Ref. No. DMOT/2021/1349
Made valid on: 23 August 2021

DECISION NOTICE

Description and location of proposal: Request from Planning Inspectorate (PINS) for SDDC's comments on a Scoping Opinion request PINS has received, under The Town and Country Planning (Environmental Impact Assessment) Regulations 2017 relating to a proposed solar farm at Oaklands Farm, Coton Road, Walton on Trent, Swadlincote, DE12 8LP

Figure 6.2.2: River Mease Catchment

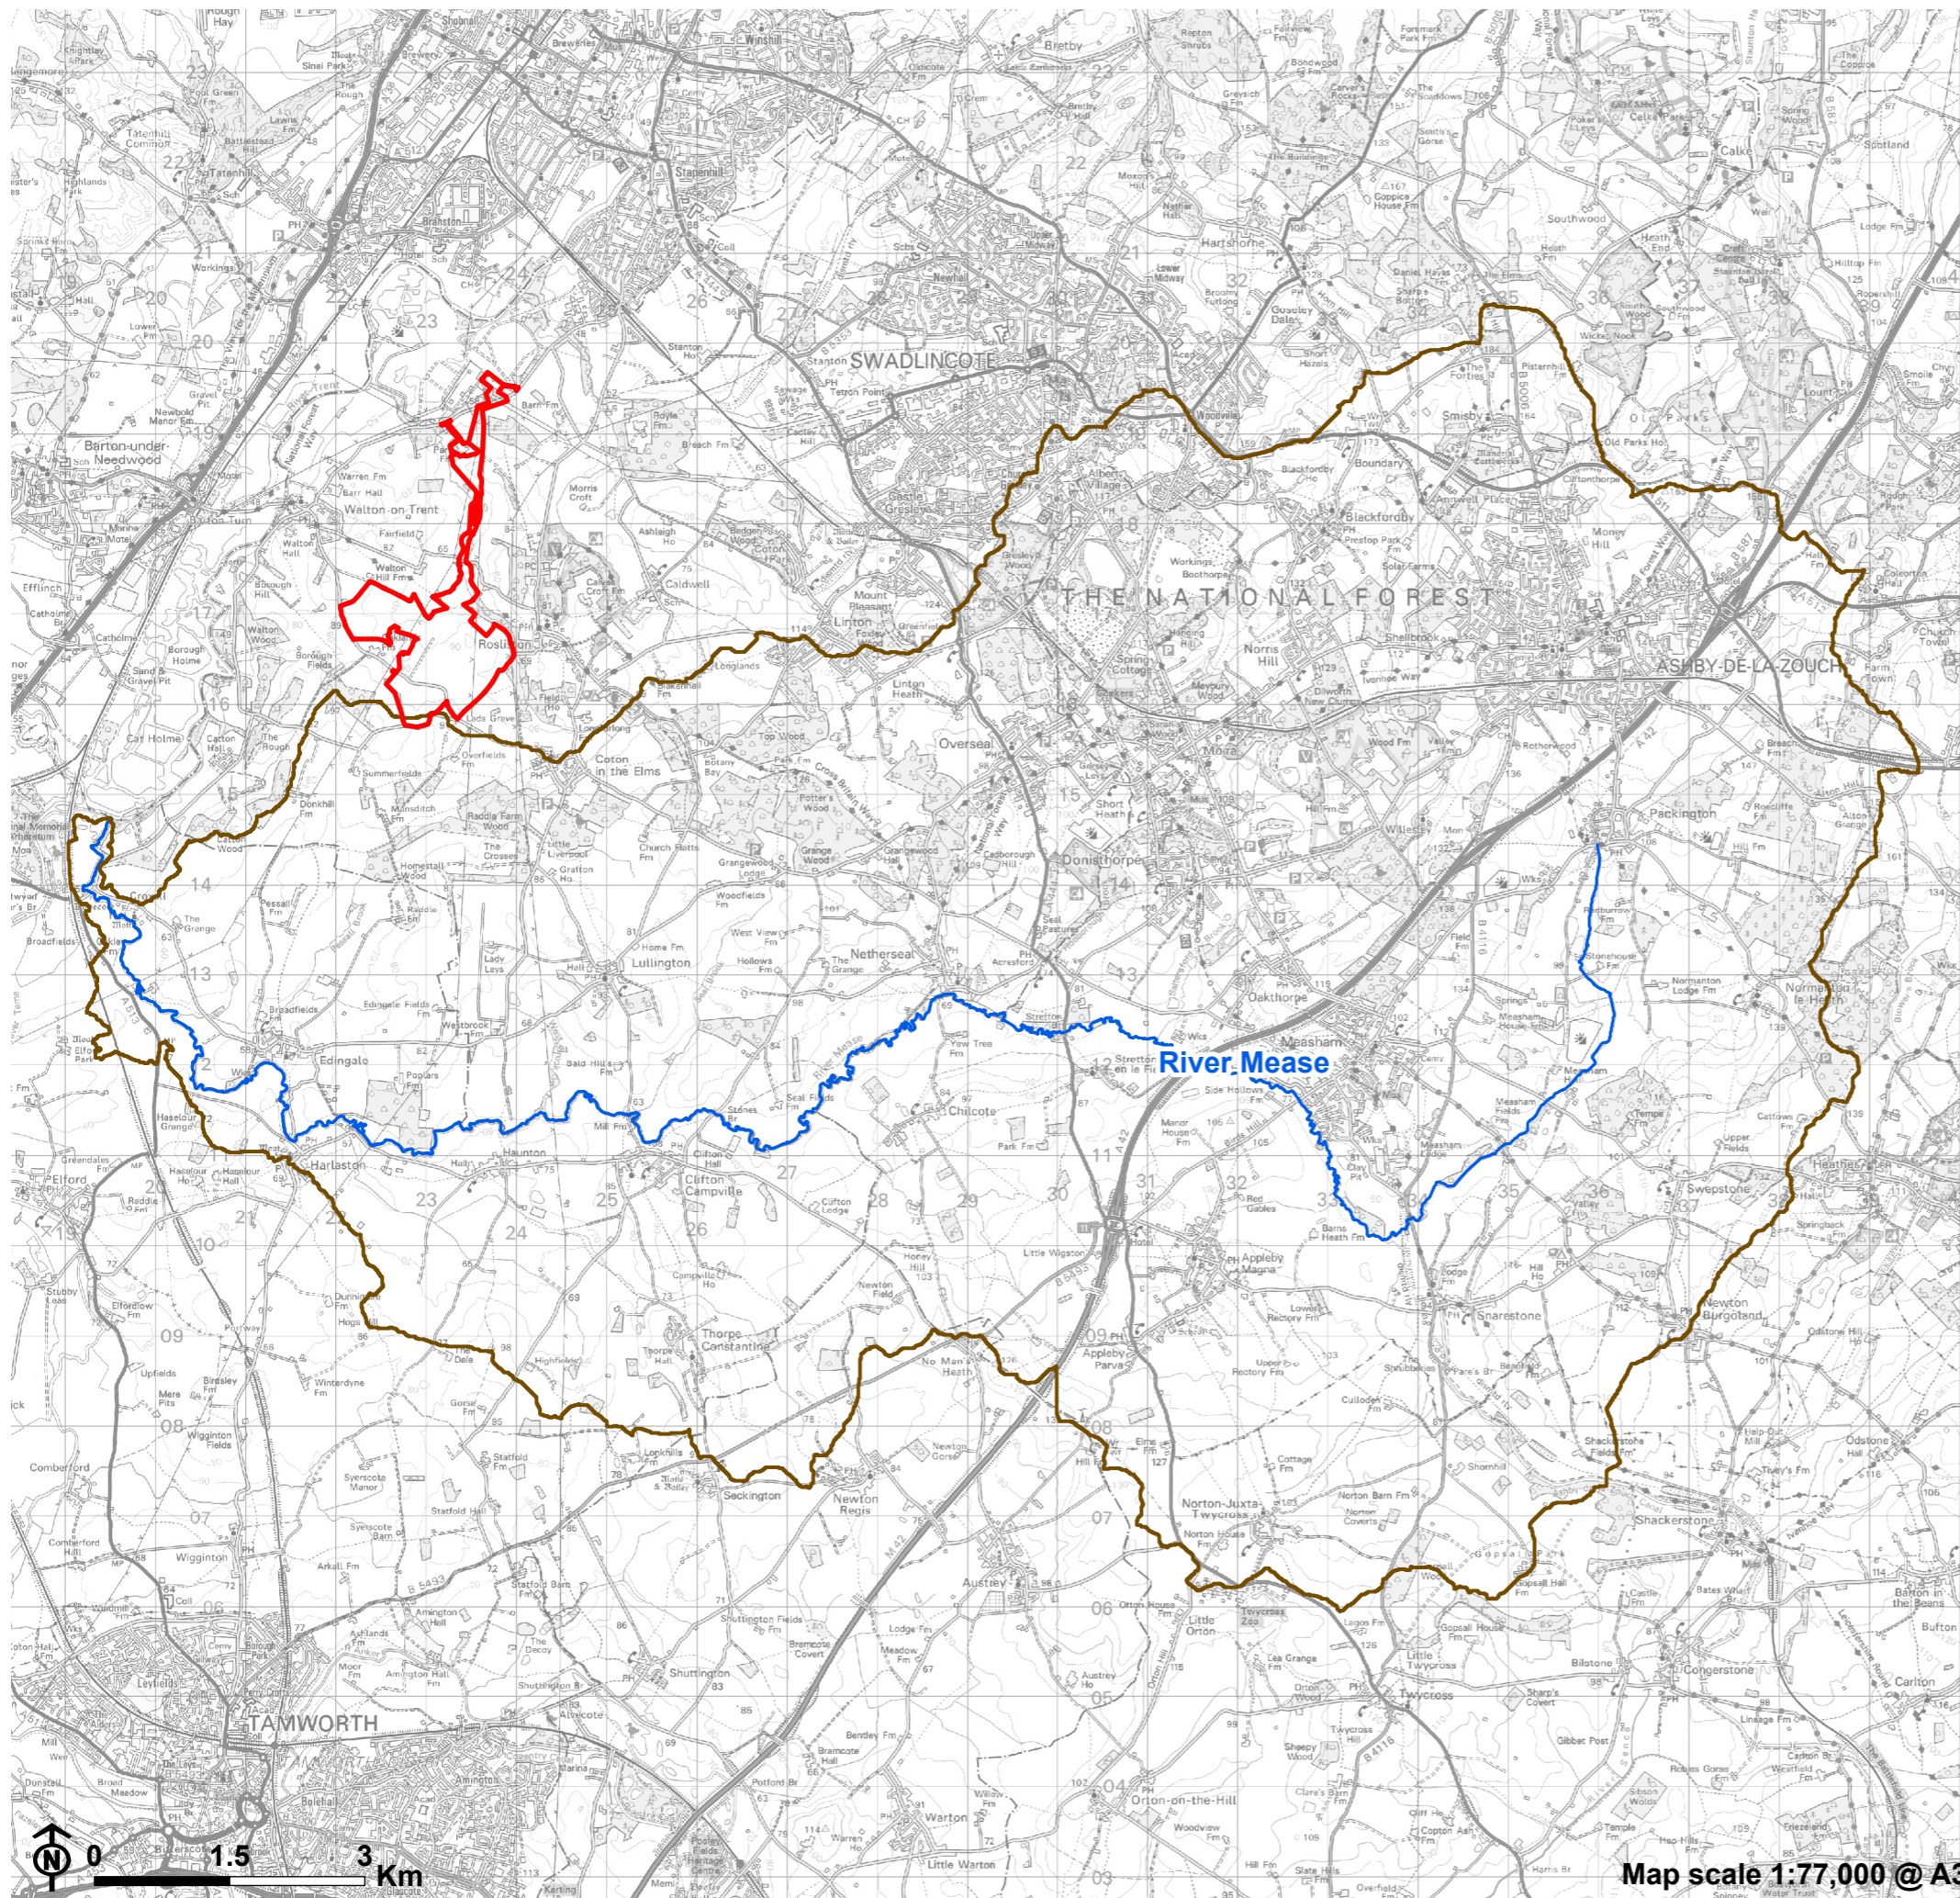
In the absence of properly considering the potential of the SAC to be affected by the scheme, there is a risk that the issues that ought to be within the scope of the EIA could be inadequately considered. By way of an example I would highlight the statements at Paragraph 10.35 and 10.36 of the scoping report. This states that:

10.35 The River Mease SAC has been identified as a potential receptor during the desk study. The likelihood of impact is considered low due to the following reasons:

- *The site of the Proposed Development is proportionally a tiny part of the overall catchment and is distant from the SAC itself (as it is in the upper headlands of one of its tributaries).*
- *Whilst there is a watercourse shown on site on OS mapping, a site walkover and conversations with the landowners have shown this to be a dry overland flow path, rather than a watercourse. This means that there is a very limited potential for a pathway to be present between the site and nearest actual watercourse.*

10.36 This issue will be addressed in the baseline Desk Top Study to be included in the application, and is not considered to lead to significant effects.

It should be noted, however, that the requirement of the Habitat Regulations is for an operation which is, or forms part of a plan or project, which is likely to have a significant effect on a European site to be considered alone as well as in combination with other plans or projects (Clause 24 of the Conservation and Habitat Regulations 2017). Clearly, whilst it may be the case that a small part of the proposed development affects only a tiny part of the wider Mease catchment the requirement to assess the scheme in combination with other plans or programmes, coupled with the fact that the SAC is already failing to meet its Conservation Objectives in respect of water quality (with excess nutrients being delivered from all of the catchments tributaries) confirms, in my view, that it is not appropriate to rule out significant effects for this reason because if any effect is likely, however limited, it could act in combination with other development to make the condition of the SAC worse.

Turning to the second point that there are no permanent waterways between the site and the 'nearest actual watercourse', the fact there is a watercourse indicated on Ordnance Survey (OS) mapping again suggests the need for a proper consideration of this issue. The most significant water quality issue affecting the Mease SAC relates to nutrients. This is mainly in the form of Phosphorous which is being delivered to the Mease through a combination of diffuse and point sources. Diffuse pollution is an identified issue in the SAC because water mobilises and transports nutrients through the landscape. The potential of land to attenuate pollutants that could affect the SAC varies considerably with hydrological settings and type of nutrient. Whilst nitrate is typically delivered to watercourses via subsurface pathways, the majority of phosphorus from diffuse sources is typically delivered in particulate form via overland flow, with the largest loads being controlled by the larger hydrological (storm) events. In simple terms a watercourse doesn't need to be permanently wet to offer a pathway to affect water quality in the tributaries of the Mease or the Mease itself. If this watercourse flows during large storm events (and the fact that it is shown on OS mapping could suggest it does flow some of the time and this is most likely during storm events) then it is entirely possible that any nutrients that could be picked up by flows from the site could transport sediments to local watercourses and ultimately to the SAC.

Finally, in respect of paragraph 10.35, whilst it may be the case, that following assessment that this site is not considered likely to lead to significant effects. The mechanism to establish the potential ways this site could affect the SAC is by undertaking a timely HRA assessment. Ahead of this, it is perhaps best not to conclude on the risk this project poses to the SAC. Moreover, the statement at paragraph 10.35 is slightly at odds with the previous statement in the Scoping Report that the *ES will specify embedded mitigation and avoidance measures during construction and operation which will ensure that contaminated run-off will not enter watercourses, and therefore adverse effects on the River Mease SAC will be avoided.* If no impact is likely as a result of undertaking this project, then mitigation would not be required. The fact that mitigation is identified to address effects could be taken as an implicit acknowledgement that this project could have a Likely Significant Effect on the SAC.

Clearly a more robust consideration of the potential ways in which this site could affect the SAC could make for a better and more co-ordinated EIA and may help to ensure issues that could turn out to be significant are not overlooked or discounted on the basis of inadequate information. Again therefore, it is suggested that greater scrutiny of the potential for effects on the SAC should be considered preferably before the final scope of the EIA is defined, but if this is not possible as early as possible during the pre-application phase so the findings of any HRA are considered within the Environmental Statement.

Figure 7.1: Heritage assets identified as potentially susceptible to effects

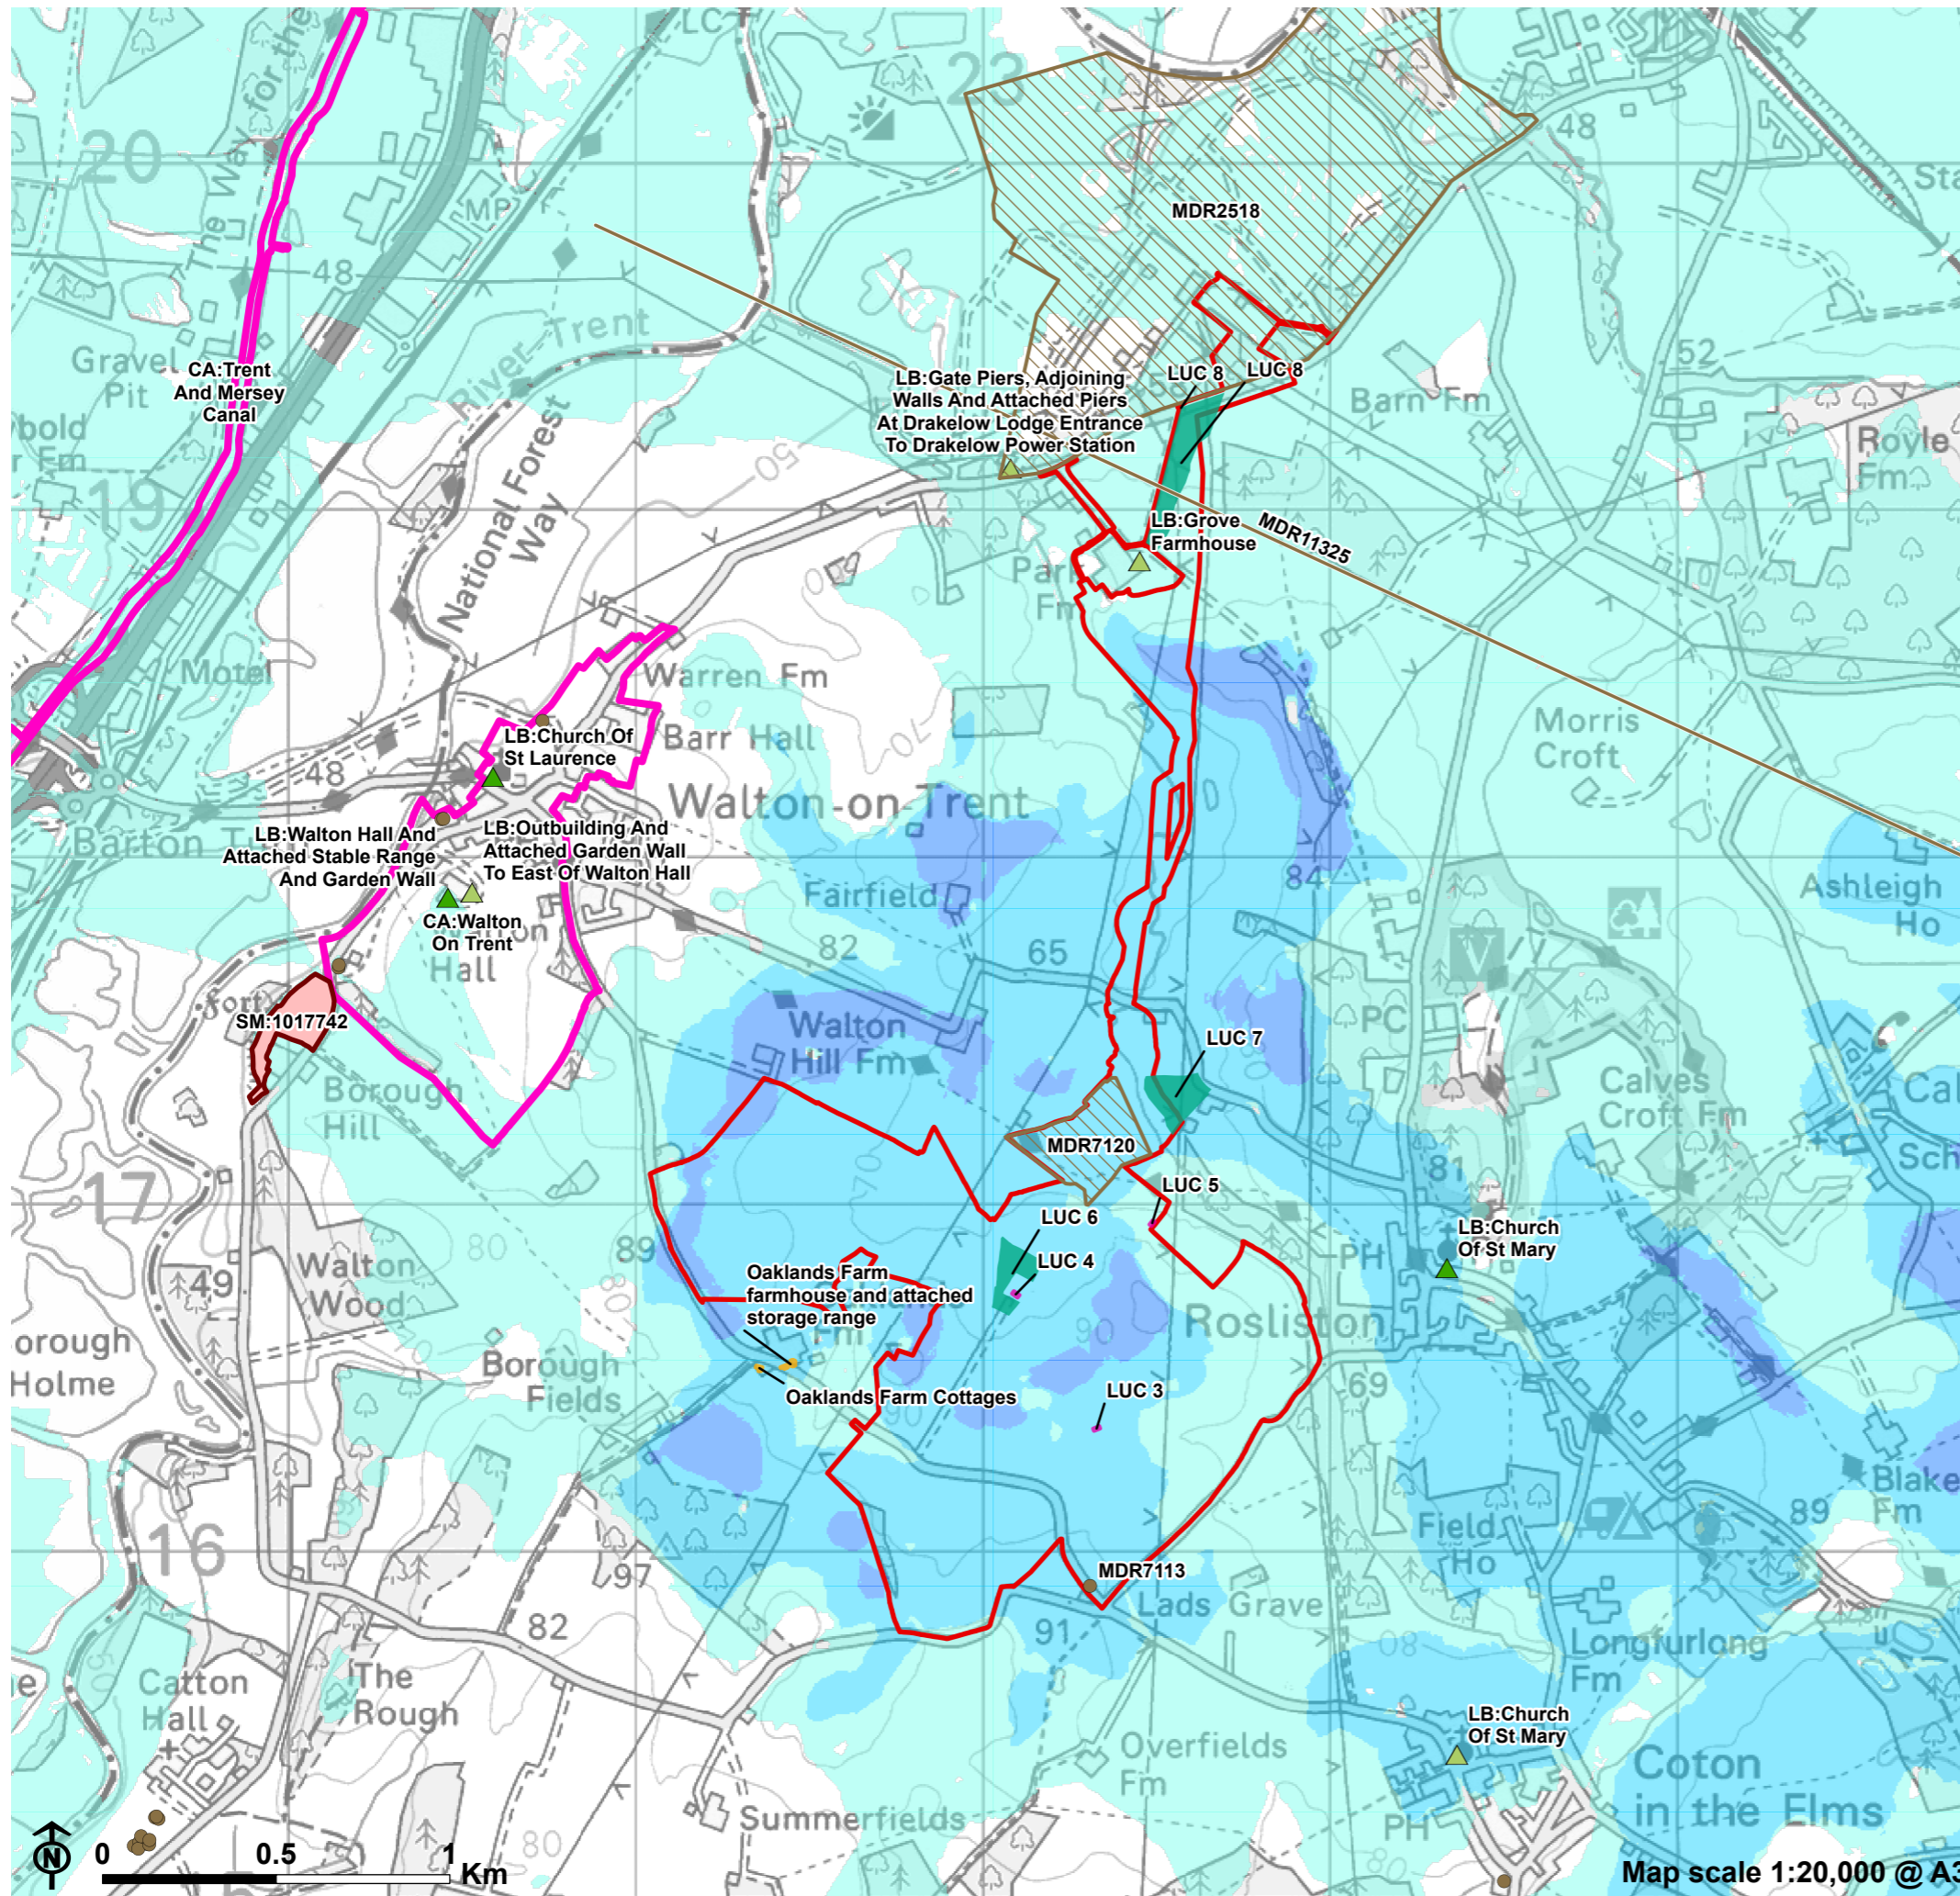
We have considered the 2.5km scoping area. Given the landscape scale of the proposed development, notwithstanding its low-lying nature, it would certainly be possible for impacts to be felt beyond 2.5 metres, particularly on any heritage assets intended to command extensive landscape views. Having considered heritage assets just outside of the proposed study area, and further afield in areas where the visibility study suggests large parts of the site would be visible, we have not identified any such assets within these areas which might justify attention, save for one which might be worth mention but is unlikely to suffer, that being Brizlincote Hall – a grade II* listed building with some grade II listed associated structures. The building was built with the intention of being a grand country house, and some work was undertaken to lay out a landscaped park, later becoming a tenanted farmhouse. The visibility assessments suggest a sizable proportion of the site would be visible from here, albeit in this direction the site would be 'narrow edge-on' minimising appreciation of its scale. As a high graded asset and one designed to relate to a wider parkland setting it could be impacted by development in the wider landscape, however the park is degraded (if it was ever fully completed) and there is other modern development nearby such that impacts will likely be considered minor at most.

As such we have no general issues with the 2.5km study area as proposed subject to some mention of Brizlincote Hall being made.

Beyond that, the approach and level of detail proposed all seems reasonable. Given the scale of the proposal officers are particularly concerned about the impact on setting of Walton on Trent Conservation Area, also the list of potential mitigation doesn't include anything that might mitigate visual impacts on setting of assets. That being said, any attempt to screen visual impacts would result in screening, the scale of which might itself have adverse impacts of its own.
